***Planning Department
Transportation Development Services***

August 14, 2015

**Re: Tam Le Salon
130 Coors Blvd., NW
Traffic Circulation Layout
Engineer's/Architect's Stamp dated 8-10-15 (K10-D047)**

# TRAFFIC CIRCULATION LAYOUT

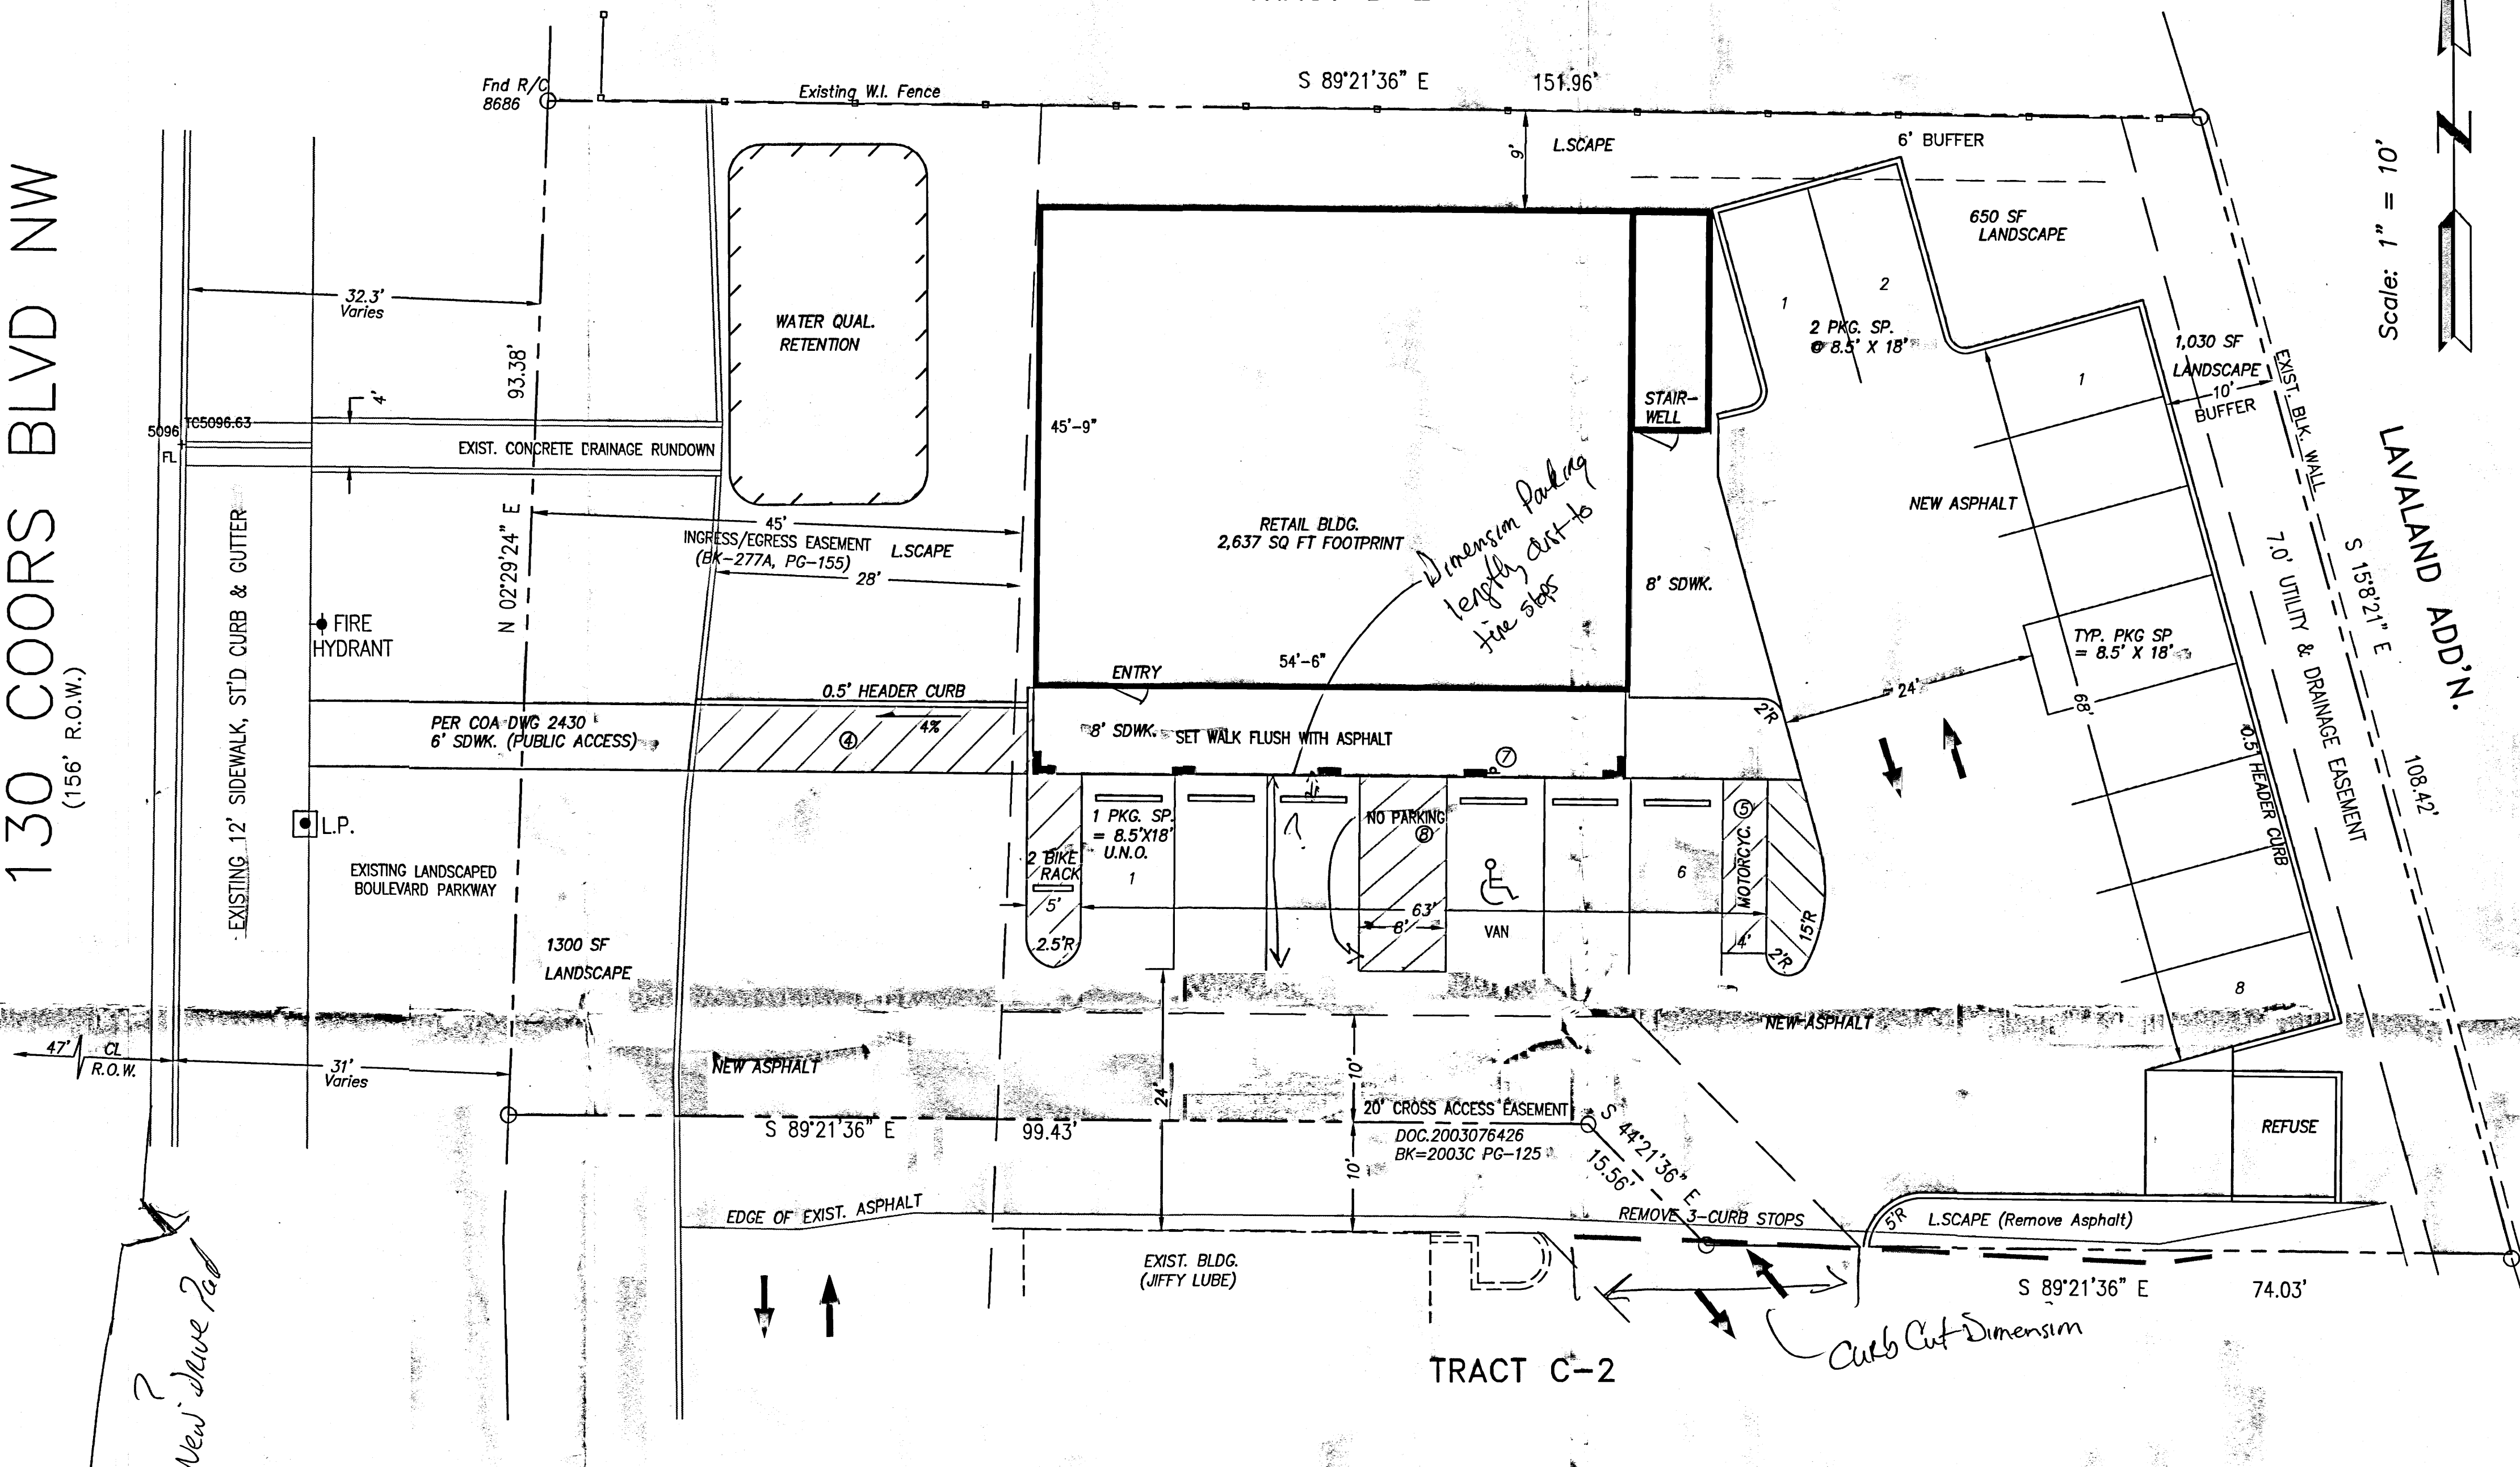
1. Identify and dimension the medians and curb cuts on Coors Blvd. for the proposed building and the existing building to the south. If there are to be no new curb cuts for the proposed building, please detail access pathway from the adjacent property's drive pad on drawing

2. Show all drive aisle widths and radii for the proposed building off of Coors Blvd.
3. Per DPM, the handicap parking spaces are to be a min. of 8.5 ft. wide and 20 ft. in length and there must be 6 ft. clear pedestrian pathway provided to building entrance. Per the submitted drawing, the ADA parking is 18 ft. in length with wheel stops and overhang, for a max. of 16 ft. in length.

4. The ADA access aisle shall have the words **"NO PARKING"** in capital letters, each of which shall be at least one foot high and at least two inches wide, placed at the rear of the parking space so as to be close to where an adjacent vehicle's rear tire would be placed. (66-1-4.1.B NMSA 1978)

5. Per the DPM, a 6 ft. wide ADA accessible pedestrian pathway is required from the public sidewalk to the building entrances. Please clearly show this pathway and provide details of ADA ramps from Right Of Way.

6. Design delivery vehicle route needs to be shown.

7. Please provide a sight distance exhibit (see the *Development Process Manual, Chapter 23, Section 3, Part D.5 Intersection Sight Distance*). Please provide this detail, if a drive pad is to be constructed on Coors Blvd.

8. Please add the following note to the clear sight triangle: "Landscaping and signage will not interfere with clear sight requirements. Therefore, signs, walls, trees, and shrubbery between 3 and 8 feet tall (as measured from the gutter pan) will not be acceptable in this area."
9. Please specify the City Standard Drawing Number when applicable.
10. Please include a copy of your shared access and parking agreement with the adjacent property owner.
11. Work within the public right of way requires a work order with DRC approved plans.
12. Please include two copies of the traffic circulation layout at the next submittal.
